SUBJECT: Engineering Review Comment  
Mountain View Electric Association Inc. (MVEA)

**Project Name: Aspen Willow Estates Final Plat**

**Project Number: SF2620**

**Description:** Proposed development of 4 lots located at 1480 Higby Rd., Monument, in Township 11S, Range 66W, Section 20.

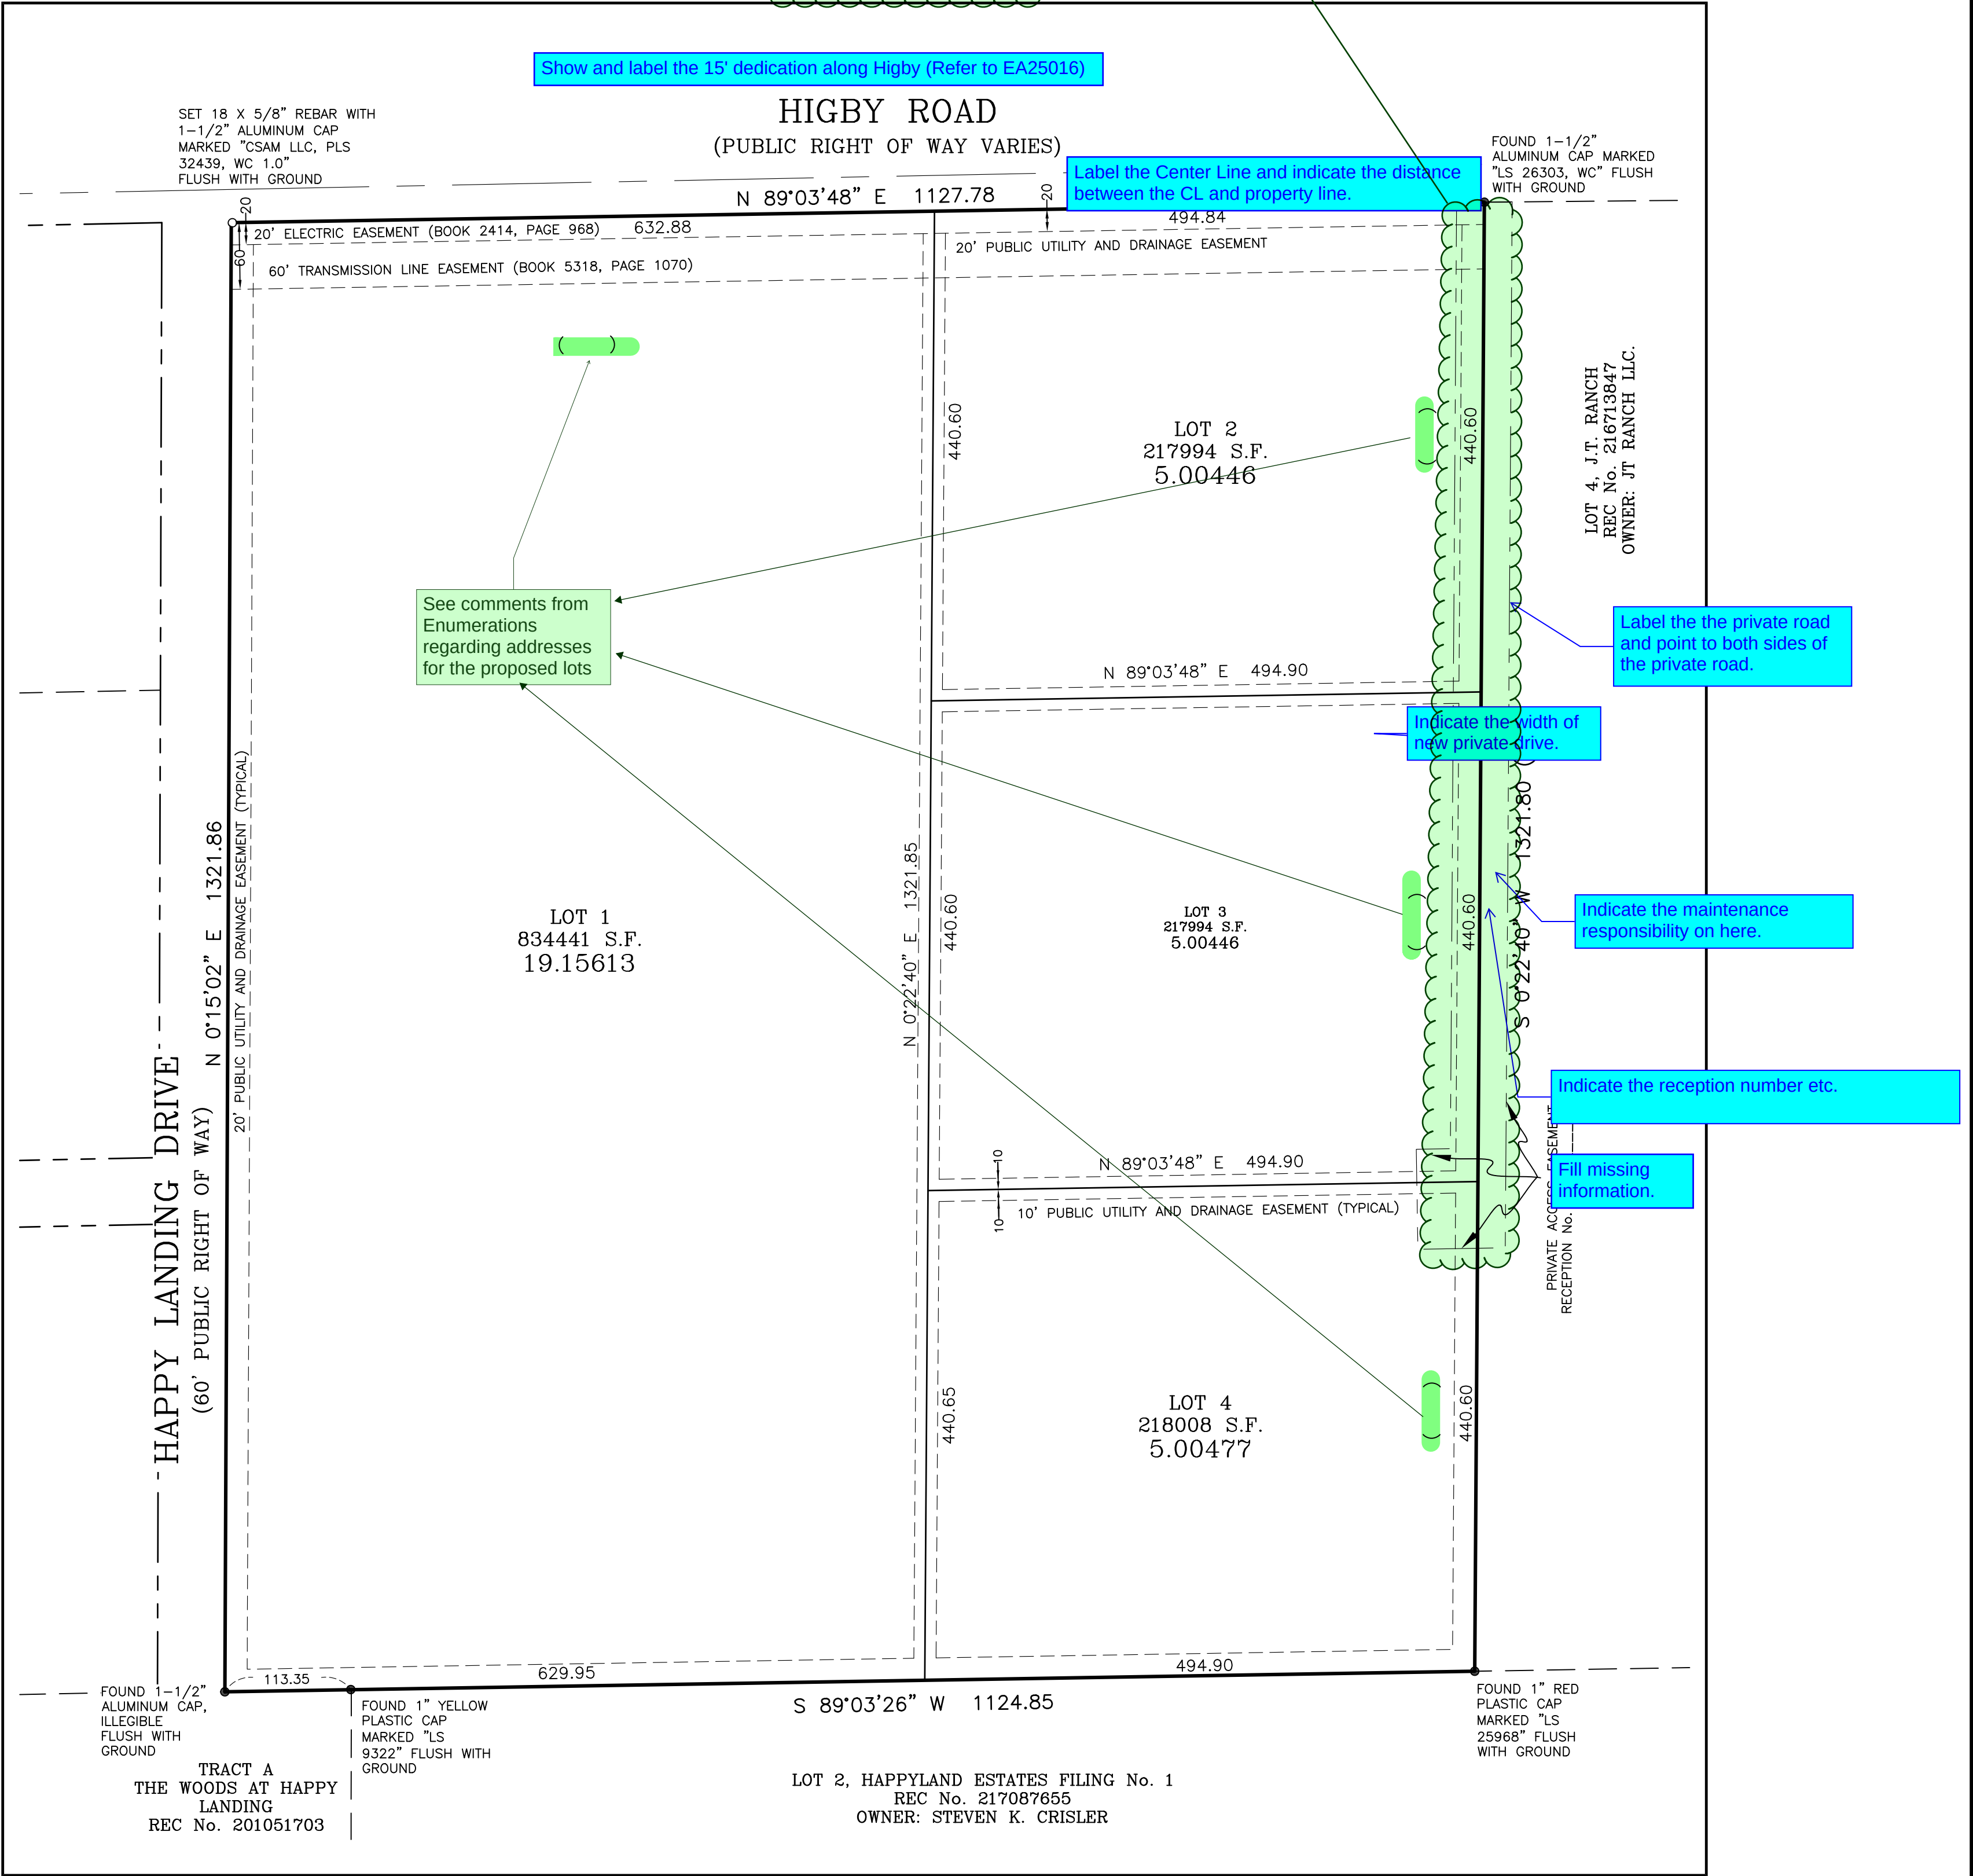
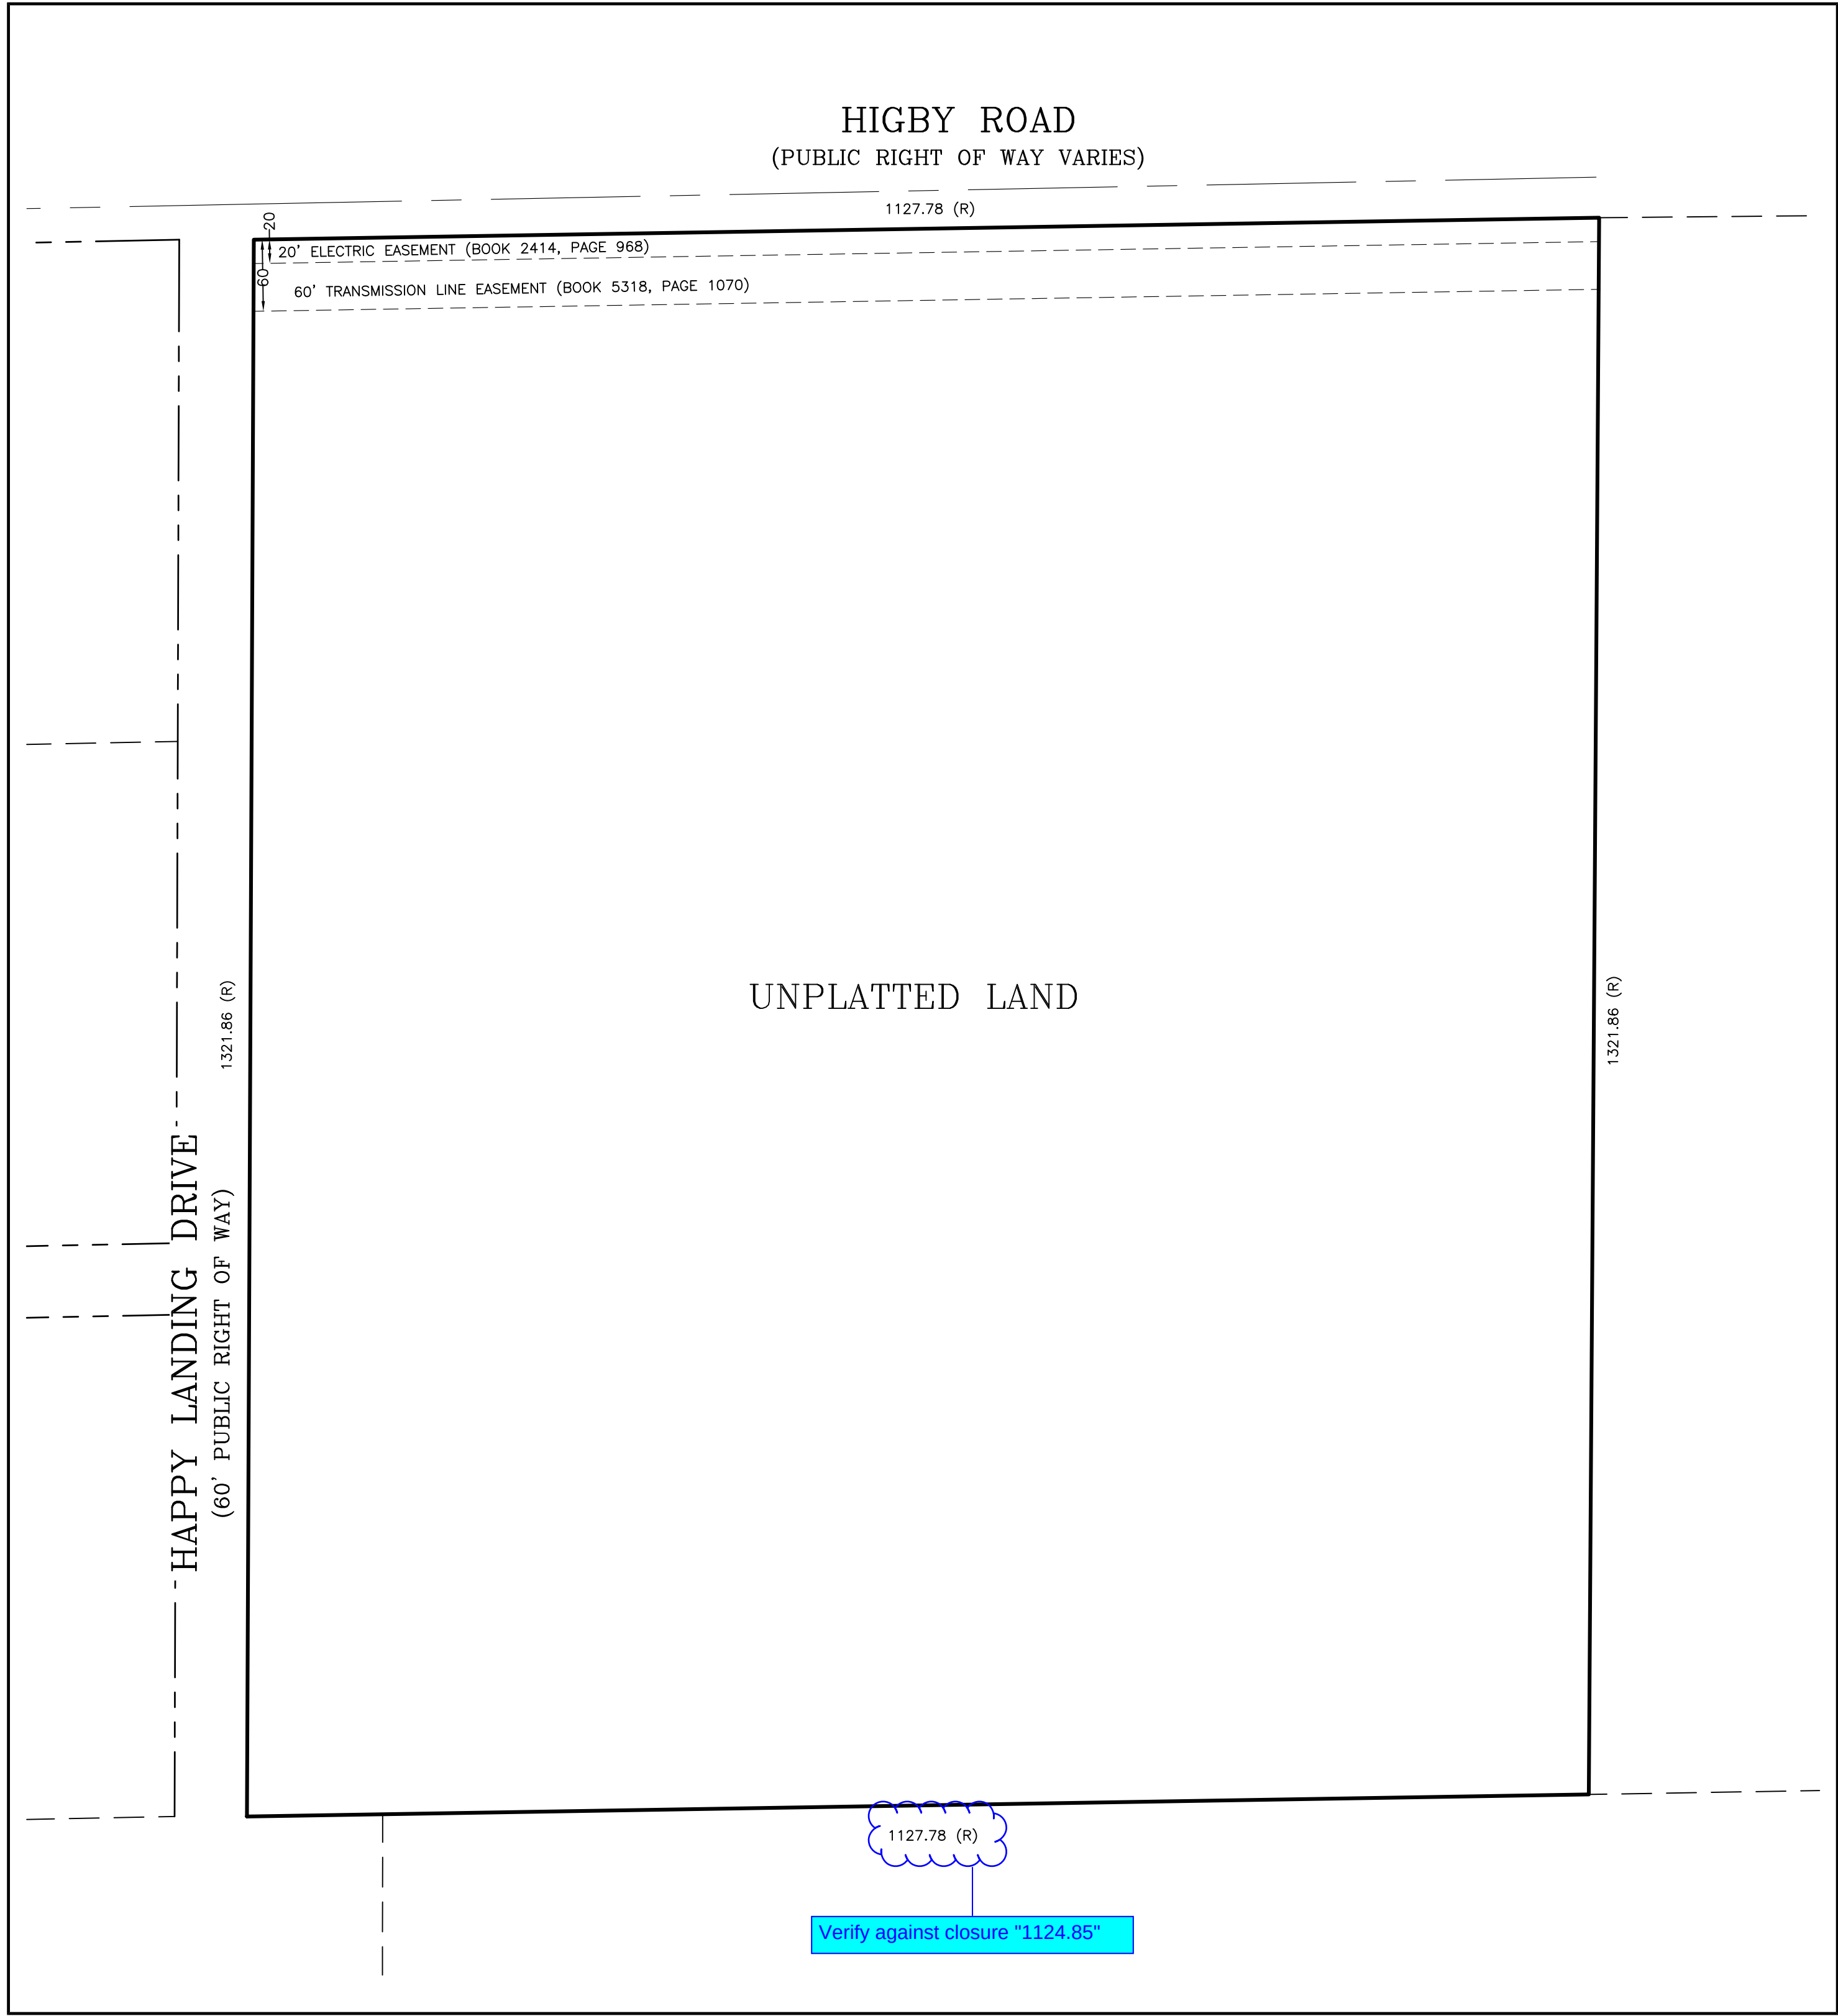
MVEA requests a ten (10) foot front, side, and rear lot utility easement and all tracts, along with a twenty (20) foot exterior utility easement on the plat. MVEA also requests the platting of MVEA's existing facilities with easements on the plat. Additional easements may be required.
